From:
Sent: 06 July 2025 15:05
To: DC Admin
Subject: Objection to Planning Application 2025/91577 – Land Adjacent to 21 Westcliffe Rise

I wish to lodge a formal objection to planning application 2025/91577, concerning the proposed development on the land next to 21 Westcliffe Rise.

FRONT

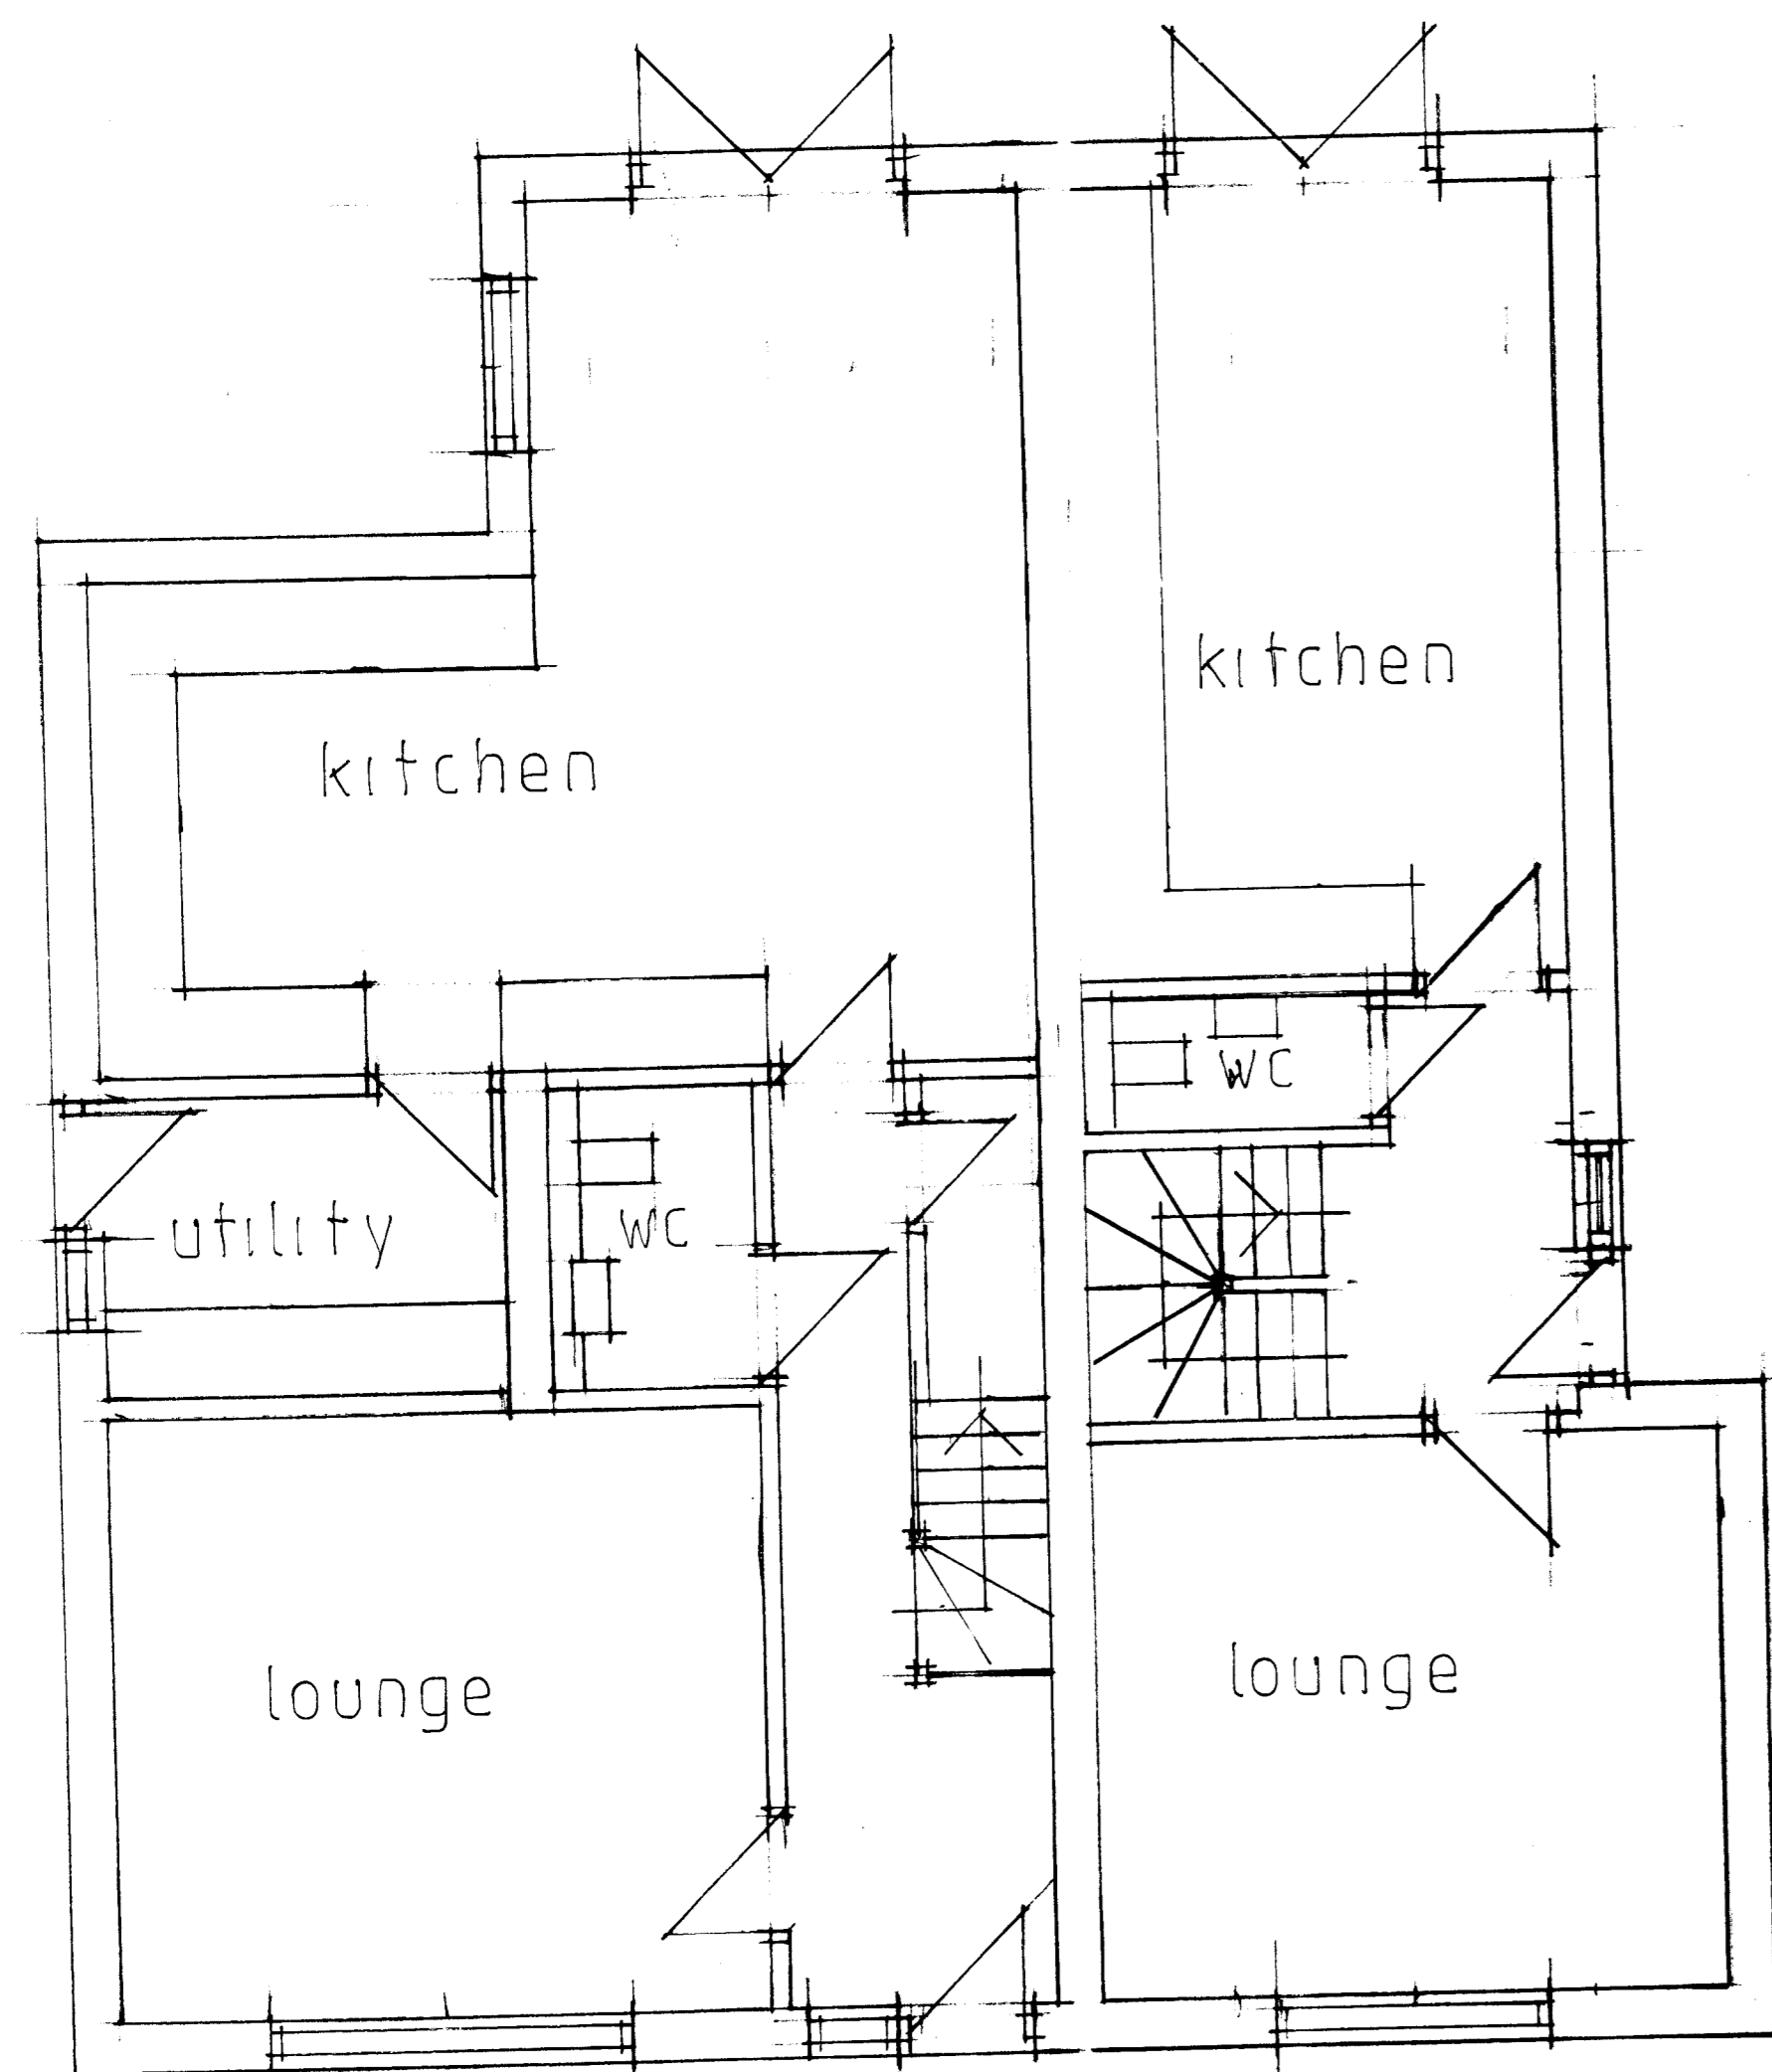
- The previously indicated scheme promised white render with grey features, in keeping with our modern property. The current proposal now uses stone, resulting in a discordant appearance that does not match our home or align with the intended modern trio of houses.

- The proposed dwellings now appear to be three storeys high, whereas the original planning permission was for two storeys. This is a significant change that further increases the sense of overbearing, overlooking into neighbouring gardens, and visual dominance from the rear. The additional height exacerbates our concerns about loss of daylight and privacy.

REAR

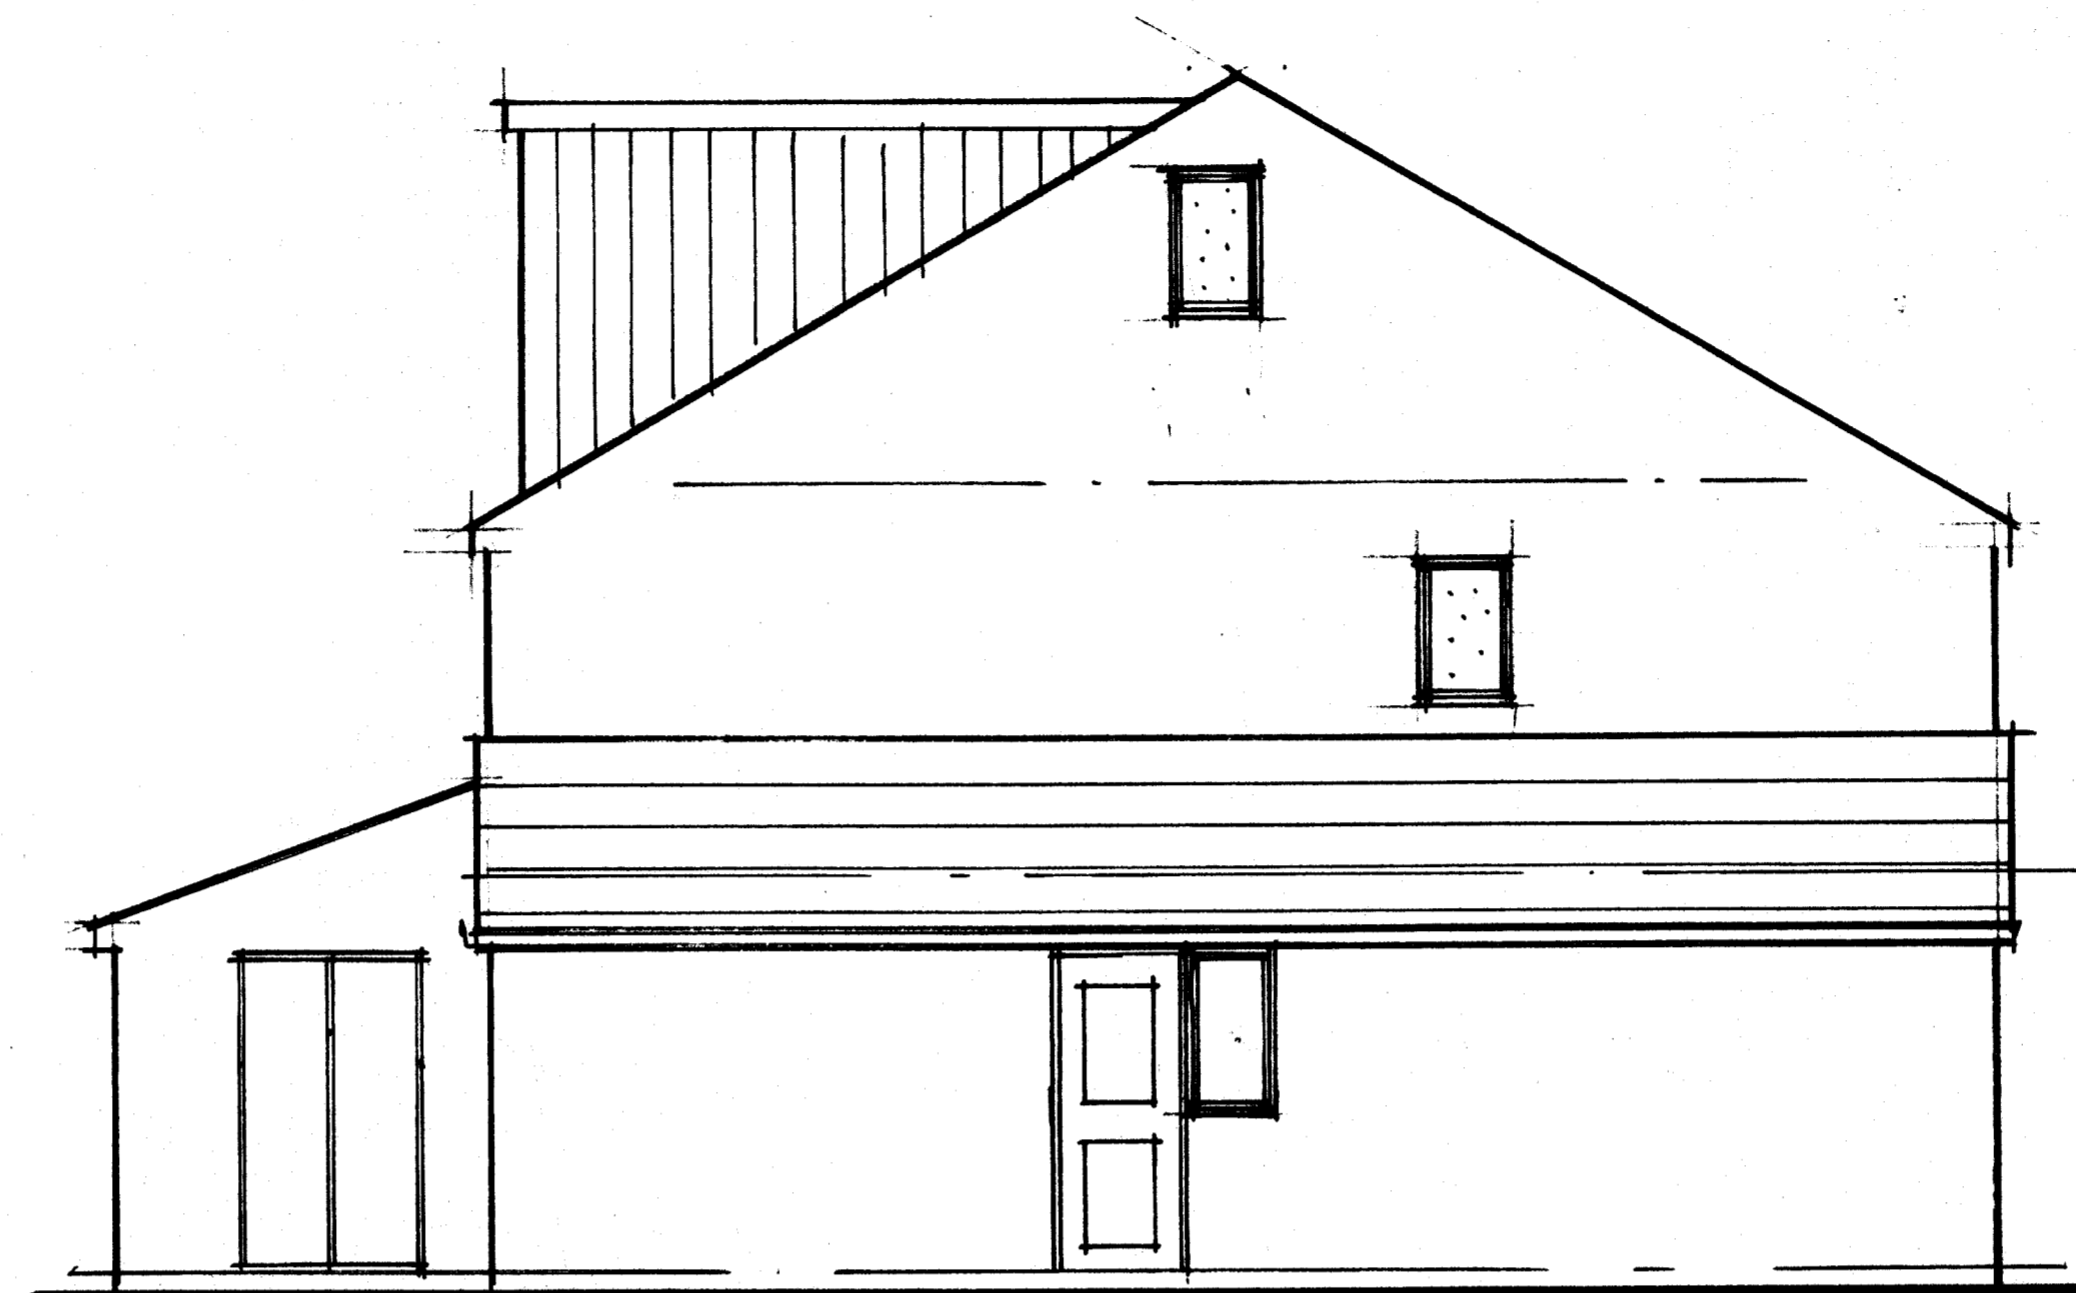
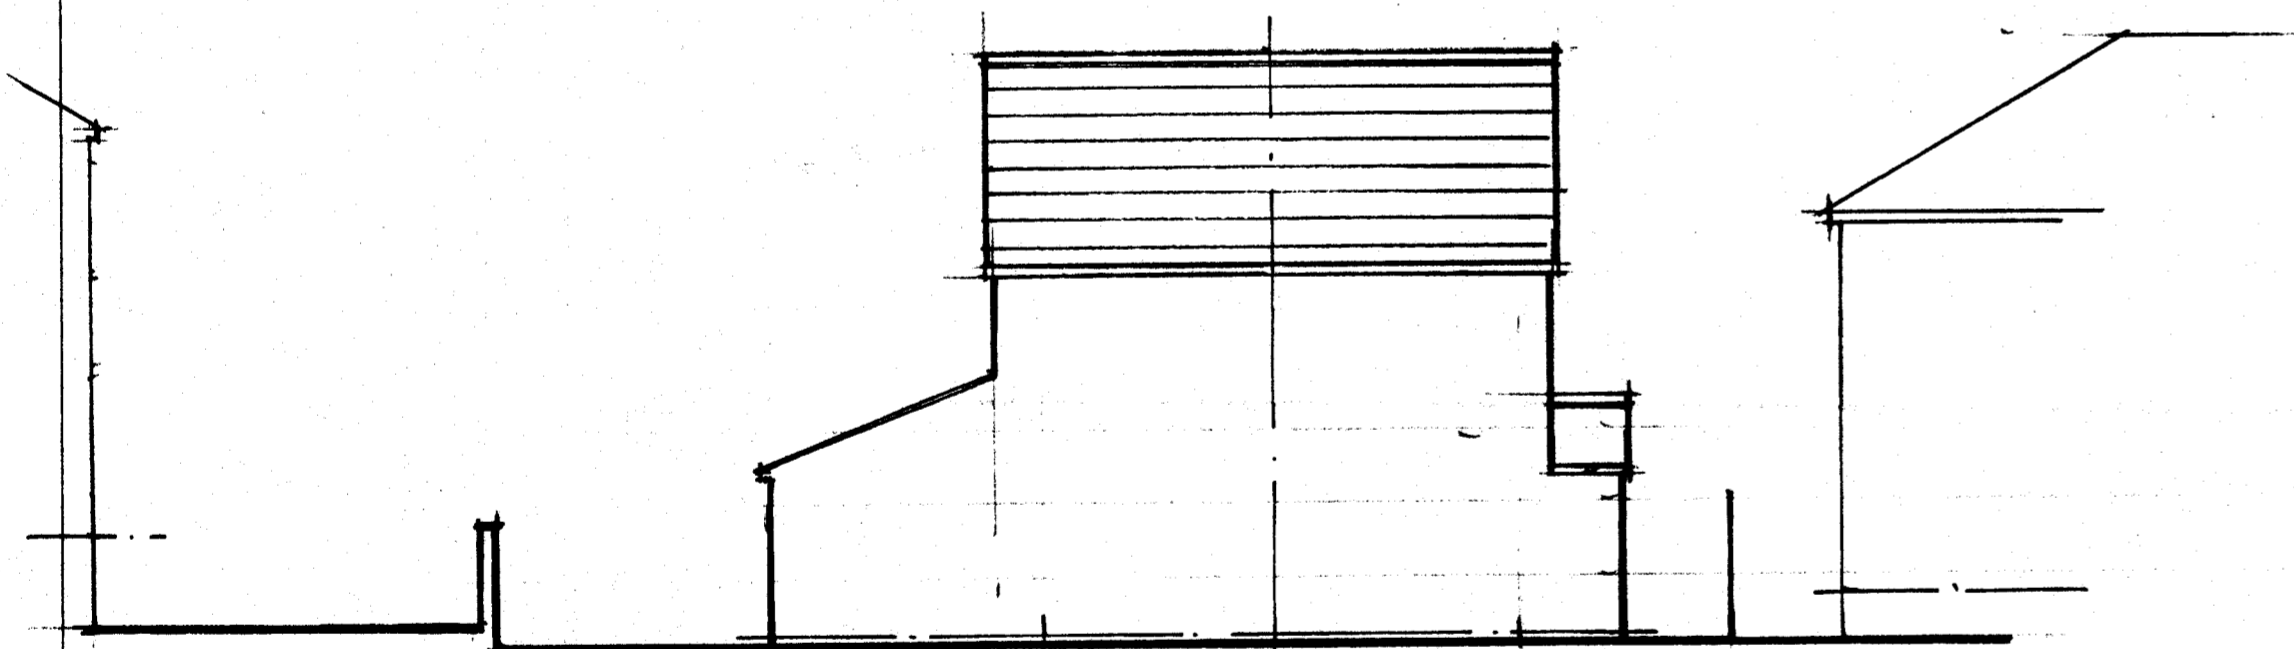
- In the originally approved plans, there were no windows or doors facing toward our property. The current drawings now include three windows and a rear door overlooking our garden, resulting in a significant loss of privacy for our home.
